## **RE: SSDA 9726 - ROYAL HALL OF INDUSTRIES - RESPONSE TO REQUEST FOR ADDITIONAL INFORMATION**

We are writing on behalf of Sydney Swans Limited (**the proponent**) to address the issues raised in your request for information (**RFI**), dated 16 December 2019 relating to State Significant Development Application (**SSDA**) 9726 at the Royal Hall of Industries, 1 Driver Avenue, Moore Park. In response to the additional information requested, further clarification is now provided in connection with the matters raised. We trust that this will assist your assessment of the SSDA.

The SSDA seeks consent for the development and operation of a multi-purpose sport and community facility at the Royal Hall of Industries (**the project**). The proposal seeks to adaptively reuse the Royal Hall of Industries, develop a two-storey high-performance sports building, and increase the permeability and amenity of the site through improvement to existing entries and public domain improvements.

OPTION 01

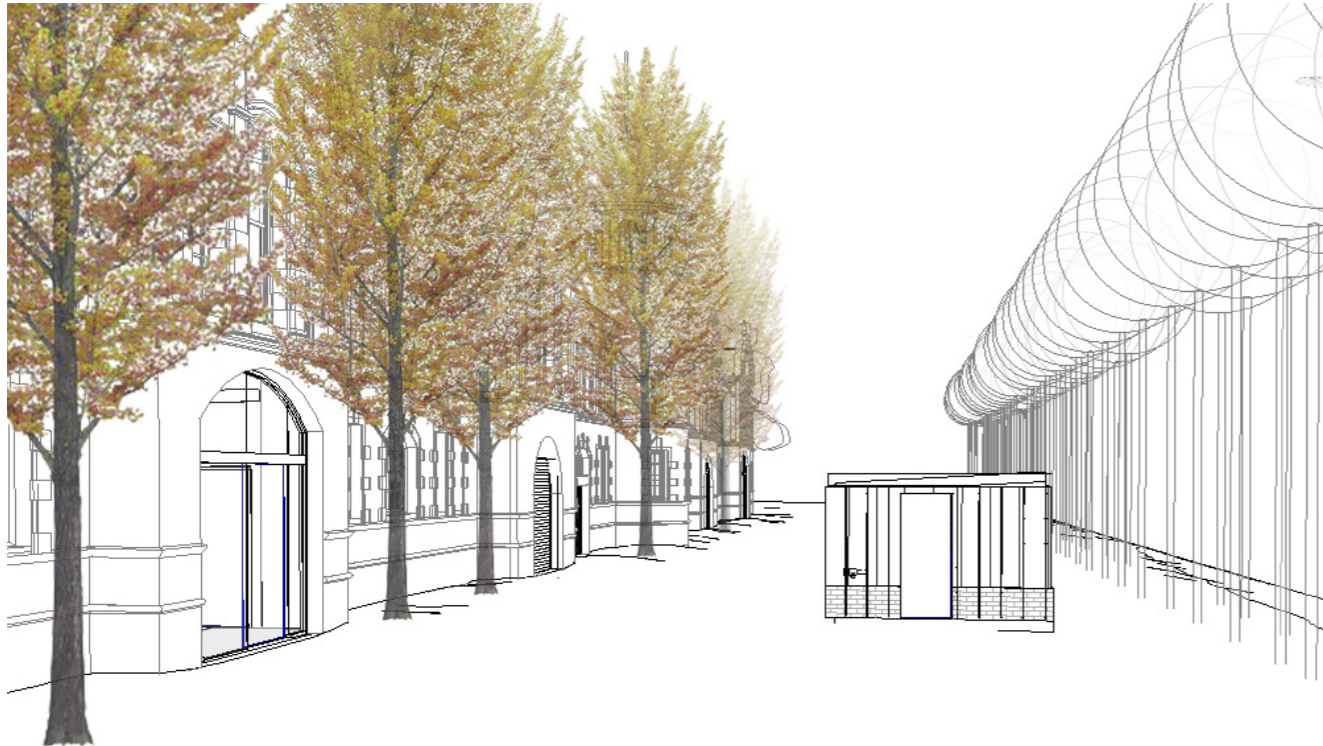
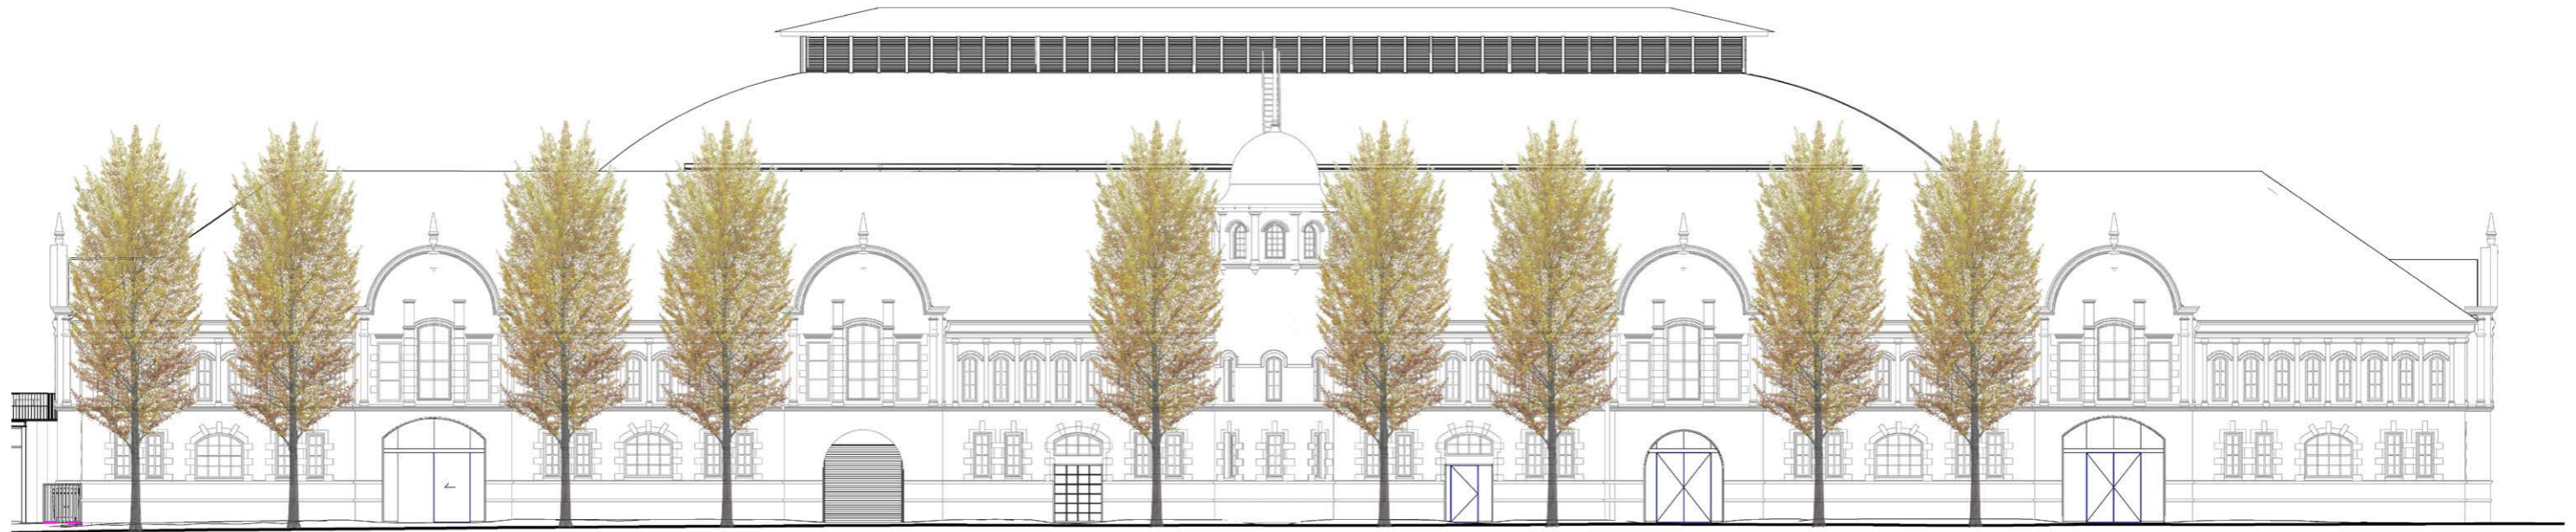
<p><b>Tree Planting</b></p> <p><i>The Landscape Plan, prepared by Arcadia, has suggested planting of 26 trees of mixed species. The majority of the selected tree species will be under 10 metres in height at maturity. The proposed tree species of Zelkova serrata 'Musashino' should be amended to native tree species that is in keeping with the surrounding vegetation.</i></p>	<p>Although they do not form part of this proposal, it is understood that the trees within the plaza are to the north of the site are proposed to be retained.</p> <p>The proposed tree species have been amended from Zelkova trees to Banksia Integrifolia species. This is detailed further in the Revised Precinct Landscaping Plan (<b>Attachment C</b>).</p>

Agency Comments	Proponent Response
<p><i>Further, the proposed tree species selection should be amended to include a greater number of trees that will grow greater than 15 metres in height and meet the City's canopy coverage requirement of 15%. The southern landscaped area (grass) between the existing palm trees and the new netball court has the potential for medium sized tree planting.</i></p>	<p>The tree species proposed for the project have been selected with consideration of the heritage significance of the existing RHI external fabric, and the maintenance of visual sightlines towards the building.</p> <p>Based on these site-specific factors, it is not considered appropriate to incorporate tree species that will grow greater than 15m in height as this will disrupt the significance of the RHI, which has been maintained as a key design principle throughout the entirety of the project. The incorporation of additional planting in the southern landscaped area would block existing view corridors towards the RHI from the south-east. This would undermine the efforts of the project team to celebrate this viewpoint and remove the traditional 'back of house' element from this southern corner.</p> <p>Notwithstanding the above, should the City of Sydney require additional planting coverage on the site, selection of an appropriate tree species for the site can be determined through a condition of development consent.</p>
